Fwd: Congress at Valley - Turn lane questions

Attached is a concept plan for Congress Street without the left turn lanes at Gilman and Valley but retaining the one at St. John Street as discussed. It seems to line up rather well, but as you can see there will be some extra striped out area in the middle of the roadway in order to achieve this design. As you review this arrangement, please note the following:

Below are some general comments on the concept you sent at the beginning of the month. Please let me know if you have questions.

Drawing file: Congress Street concept / ada bus shelter.pdf

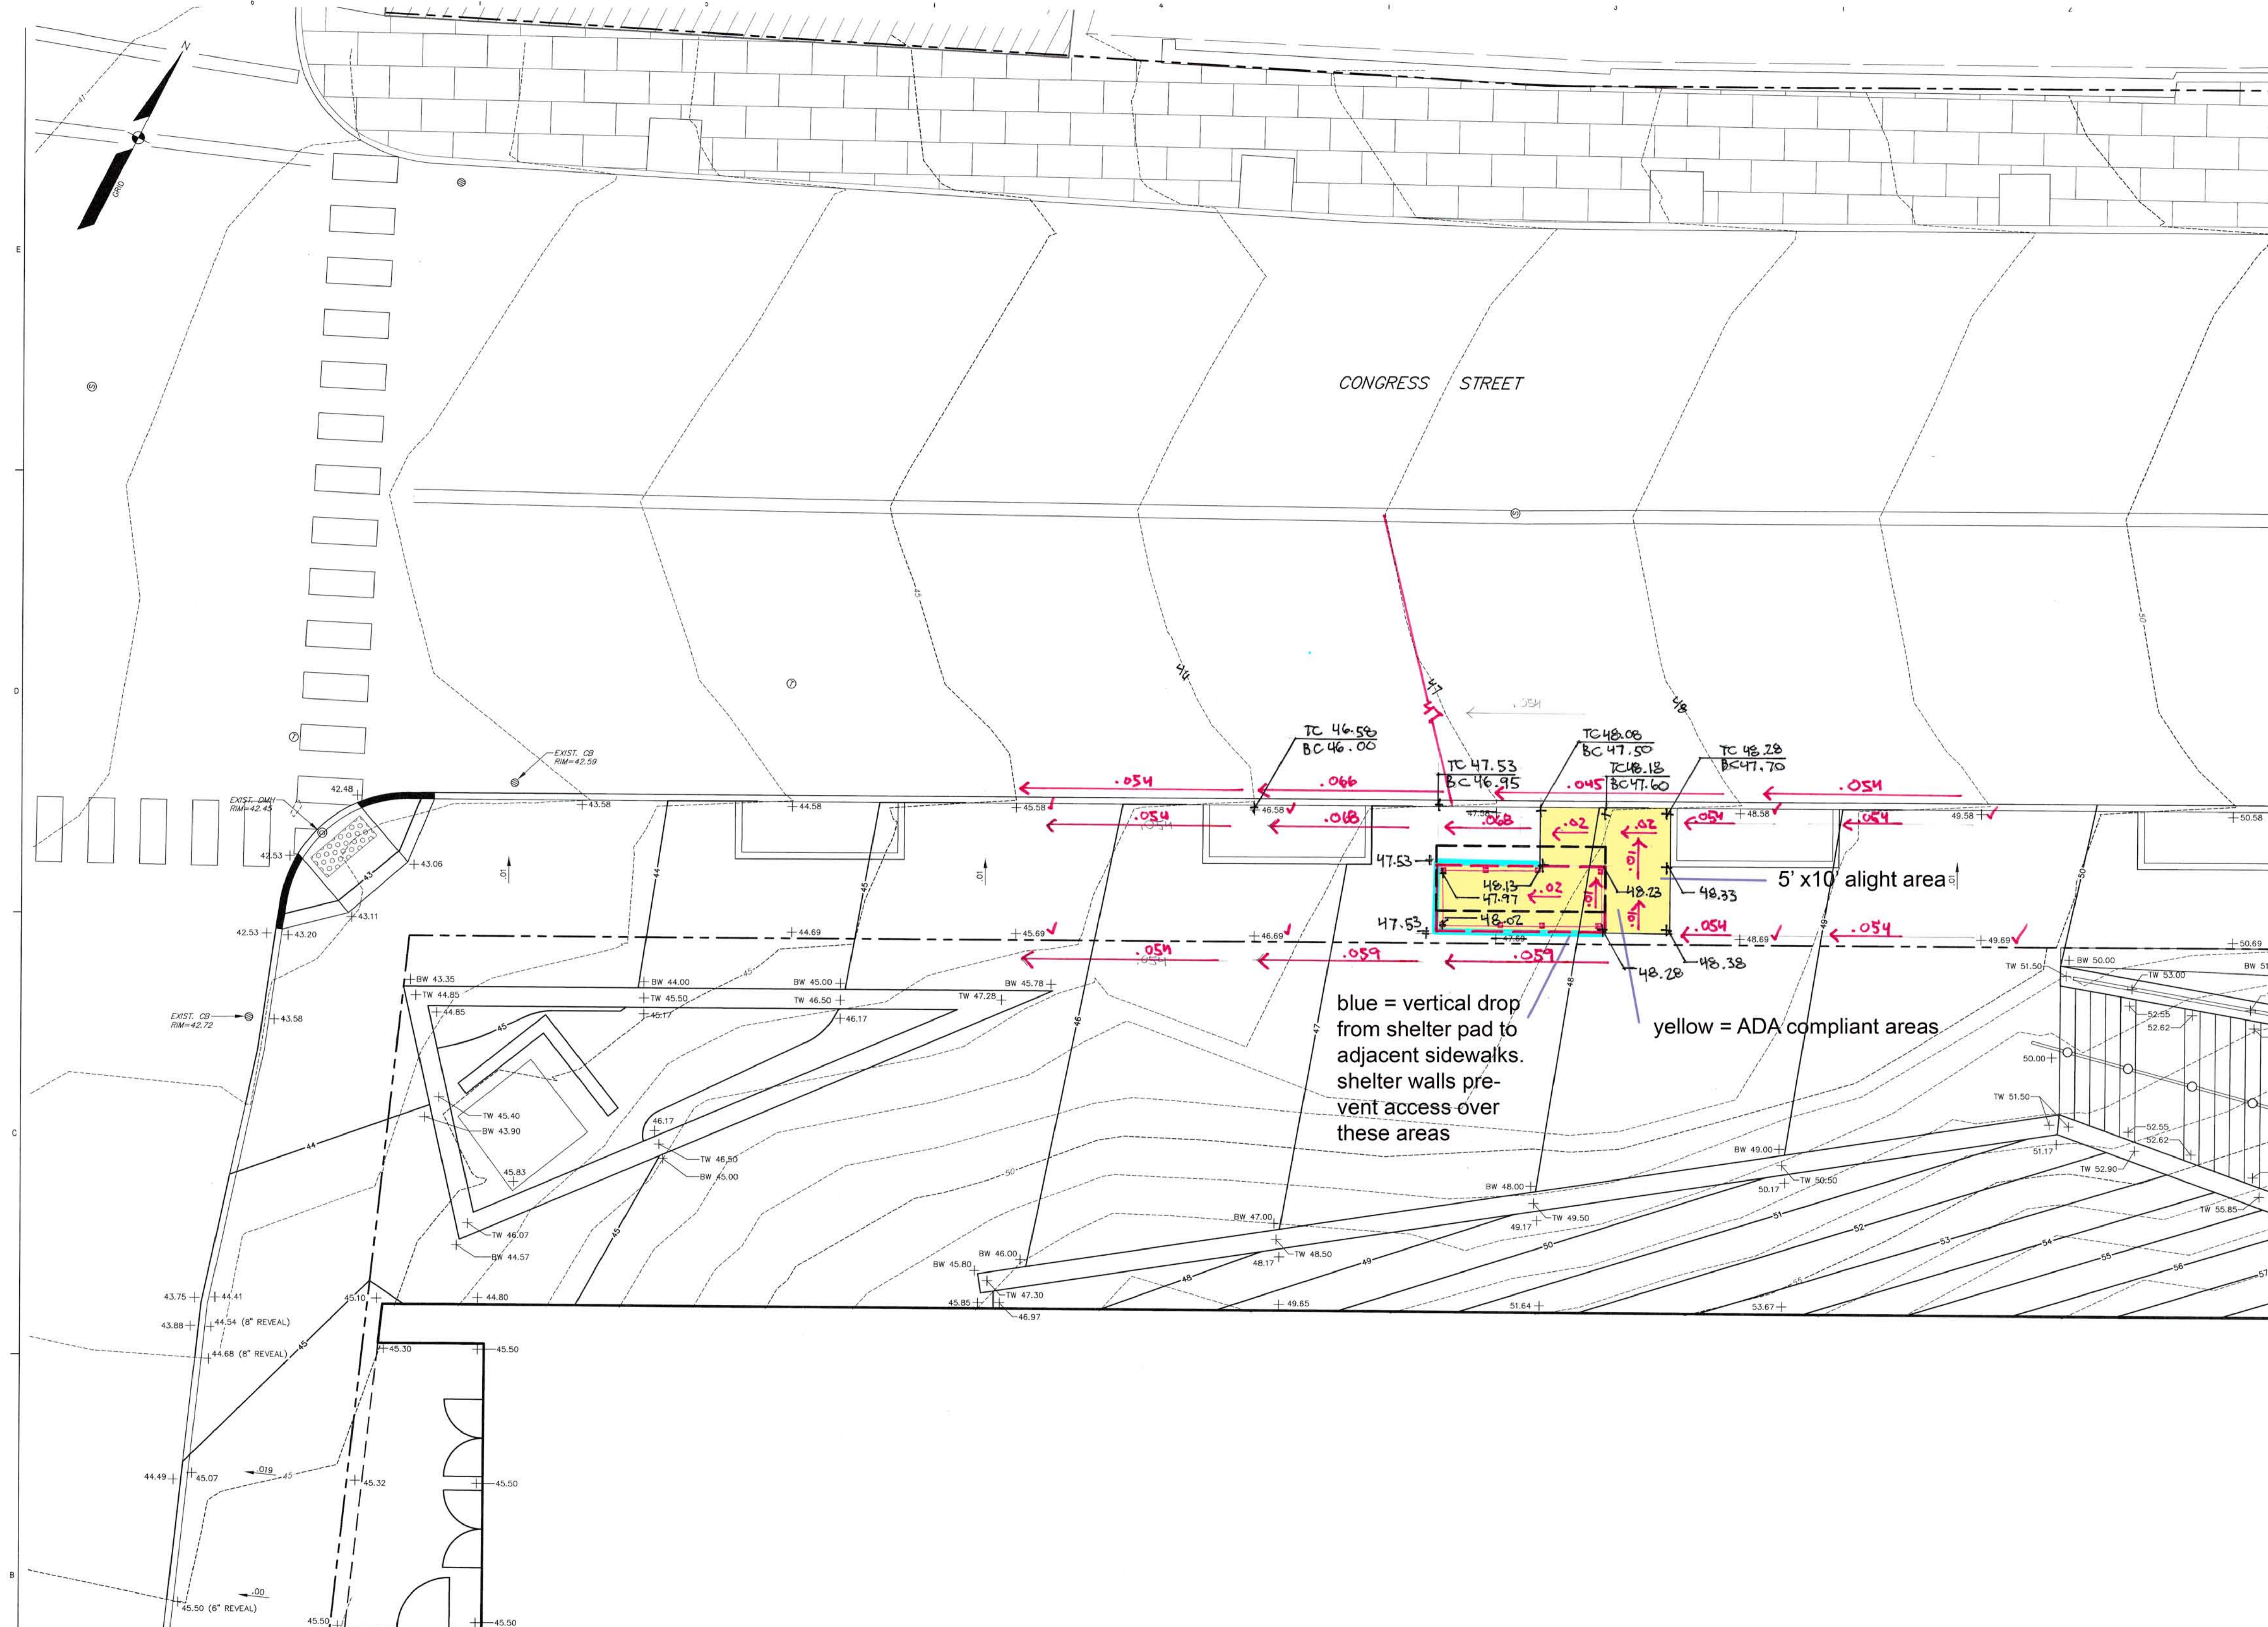
- The concept does not appear to reflect the work done up to the Planning Board's approval with conditions that include the southerly curb line of Congress Street from Gilman to the Visitor's Garage entrance moving out ~4' to enable the bus stop/bus shelter to be ADA compliant and have enough room behind the shelter for pedestrian access.
